Comments on Albion Land's Design for New Roundabout at Catalyst Development, Bicester Version 2.1 6 May 2020 Paul Troop

1. This note has been written by Bicester Bicycle Users' Group (BBUG) to respond to a proposed roundabout design set out in a Technical Note written on behalf of the developer of Catalyst, Albion Land.

JOB TITLE CATALYST BICESTER		CLIENT ALBION LAND	
DRAWING TITLE WENDLEBURY ROAD SITE ACCESS ROUNDABOUT			
SCALE 1: 500@A1	DRAWN BY RJM	DATE 03/05/19	DRAWING No 19539-12-02
REVISION B

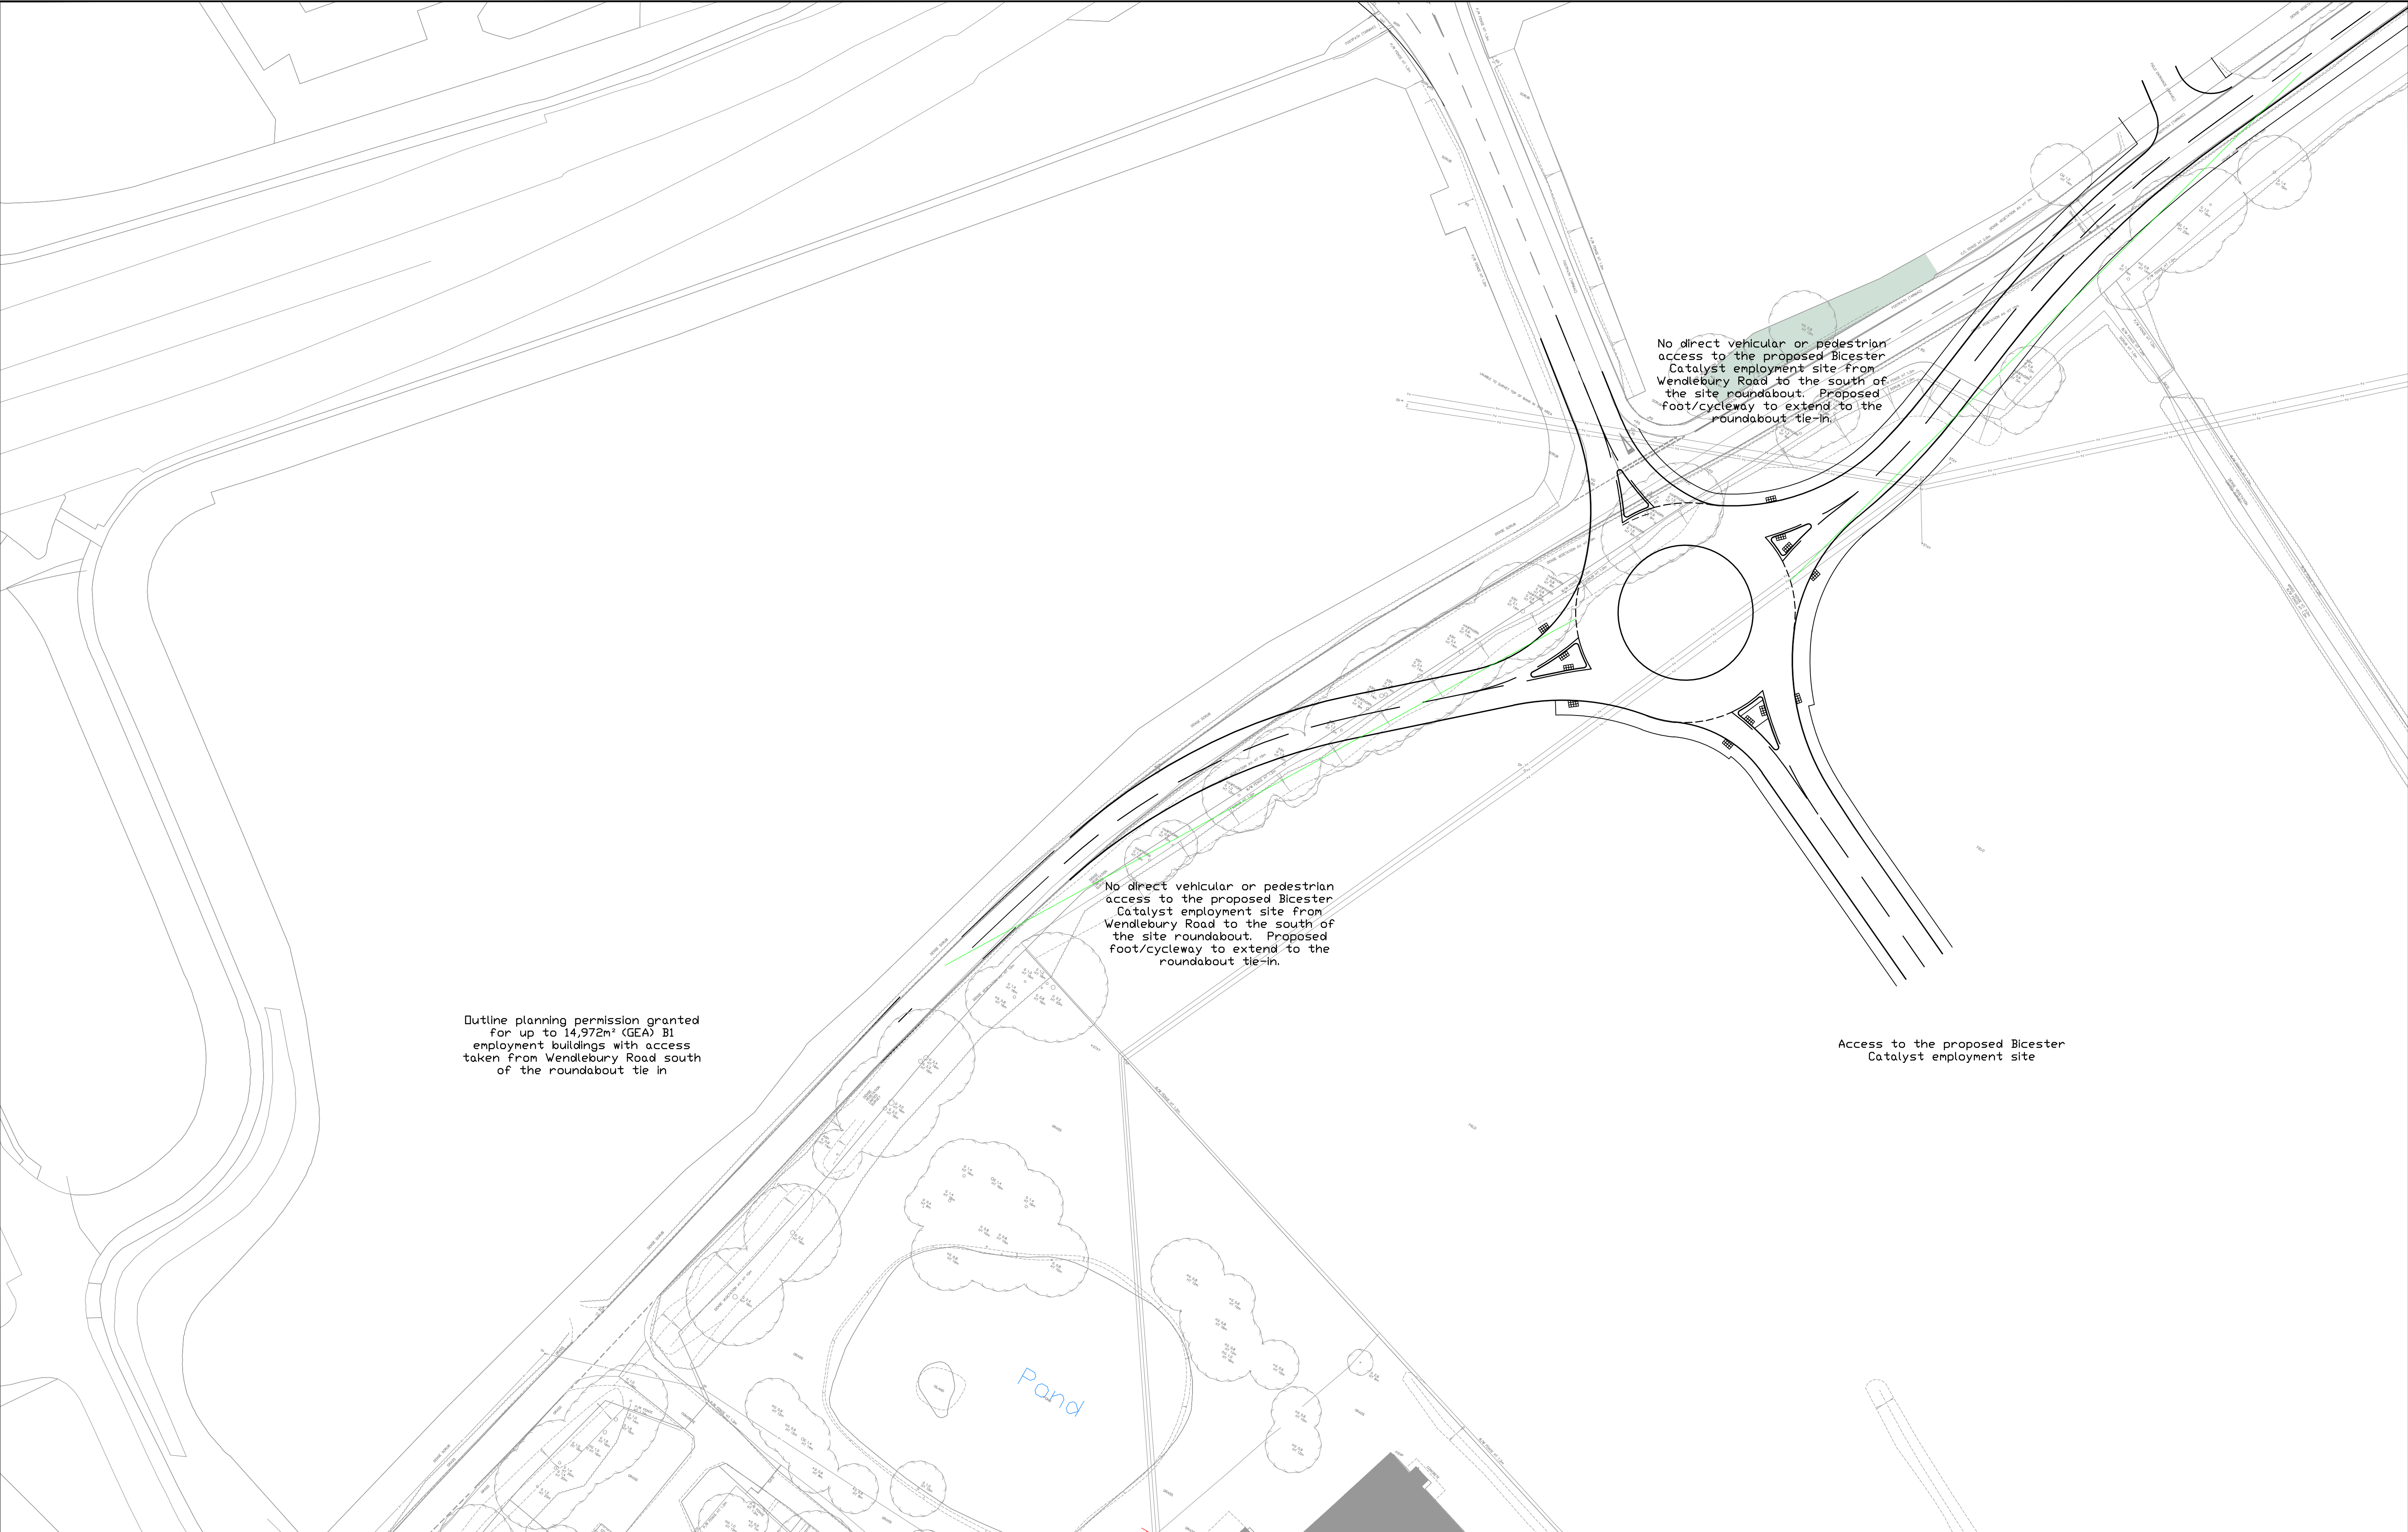
a. There are pedestrian only links and missing cycle links, which will confuse users, encouraging vulnerable cyclists onto the carriageway, and force vulnerable cyclists to use paths currently envisaged as pedestrian only, leading to unnecessary conflict. This will undermine active travel, and is contrary to the Oxfordshire Cycle Design Standards.

c. There is no horizontal separation between the carriageway and the shared paths in a number of areas. This is contrary to

d. There are no waiting areas for pedestrians and cyclists waiting to cross the road. This will block the shared path, causing serious usability issues for pedestrians and cyclists.

e. There are no transitions between the shared paths and the carriageway, which is dangerous and contrary to design standards.

10. The developer's design makes no provision for cyclists whatsoever in the area next to the Bloombridge 1A development. The planned downgrading of provision here to pedestrian only facilities by the developer's design does not appear to be justifiable, and is contrary to the Oxfordshire Cycle Design Standards in that it fails to provide any paths for cyclists travelling, to, from, or via this location:

17. In four areas, there is no horizontal separation between the shared paths and the carriageway (see Figure 4).

21. Currently, there are no waiting areas in three locations (see Figure 5), meaning that users waiting to cross the carriageway will block the shared path for other users, causing serious usability issues, undermining active travel.

24. There are no transitions between the shared path and carriageway at two points (Figure 6).

a. The pedestrian only facilities on west side of Wendlebury Road North become shared pedestrian and cycle facilities;

b. Cycle links be provided across all arms of the Catalyst roundabout; and

c. Provision is made to permit future connection of the shared links on the Catalyst roundabout with shared links on Charles Shouler Way.

20. BBUG suggests that horizontal separation of at least 0.5m is instated between the shared paths and the carriageway.

23. BBUG recommends that waiting areas be provided. Waiting areas can be created by moving the shared paths away from the carriageway as recommended in the previous section. The developer has informally indicated that it is willing to consider introducing waiting areas on the crossing points on the entry to the Catalyst development only.

27. BBUG recommends that transitions are introduced on the Wendlebury Road South. The developer has informally indicated that it is prepared to consider introducing such transitions.
